### **MEMORANDUM**

FROM: Christina Wollman, Planner II

DATE: December 5, 2007

SUBJECT: Additional Information Requested  
Big Buck Ridge Plat

PROJECT#	SHEET: 2
2007-389	OF: 3

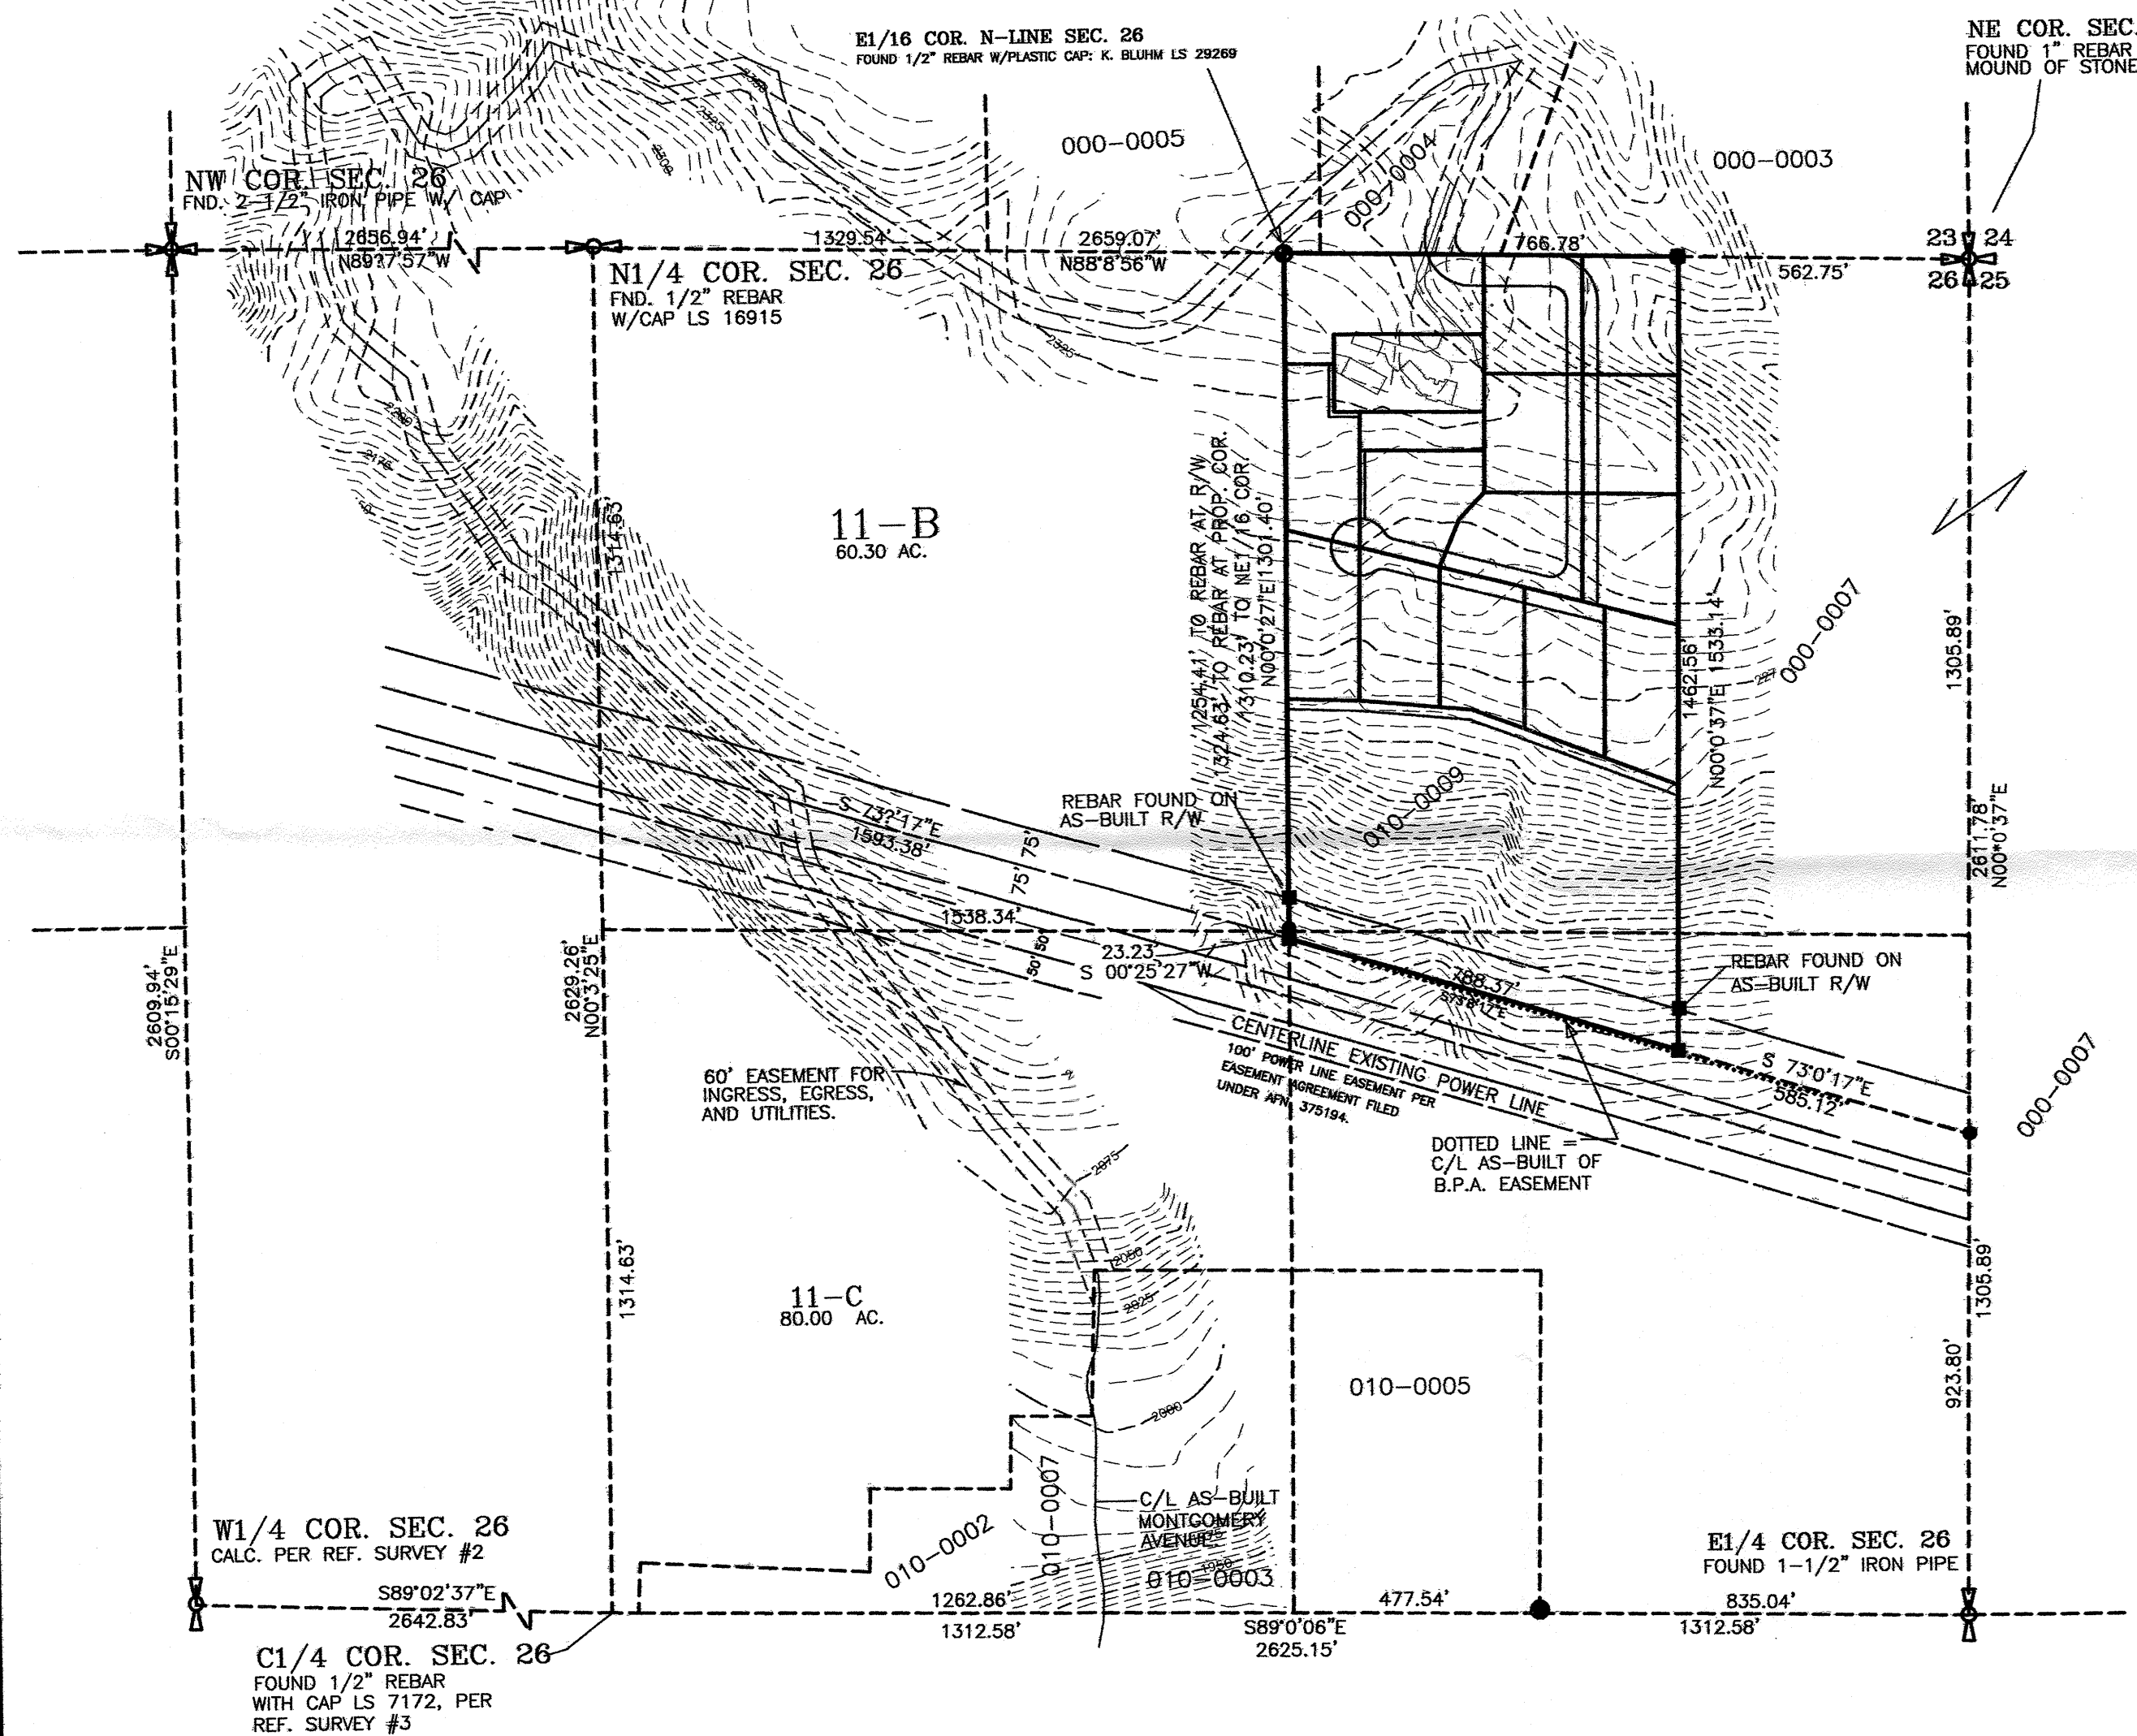
Deer Creek Road currently serves more than 40 lots. Per Kittitas County Road Standards 12.01.095(2), a second access is required. The second access shall be identified prior to preliminary approval.

All roads that serve more than 40 lots are required to have two interconnected ingress-egress routes that independently connect to an on-system county road.

If the second access is restricted to emergency access only, it must meet or exceed the following requirements: 60' easement, 20' roadway width, BST/ACP surface, and a paved apron. Access restrictions such as gates or bollards must be approved by the Fire Marshall.

If the second access is to be used for ingress and egress, it must meet the same standards of the first access.
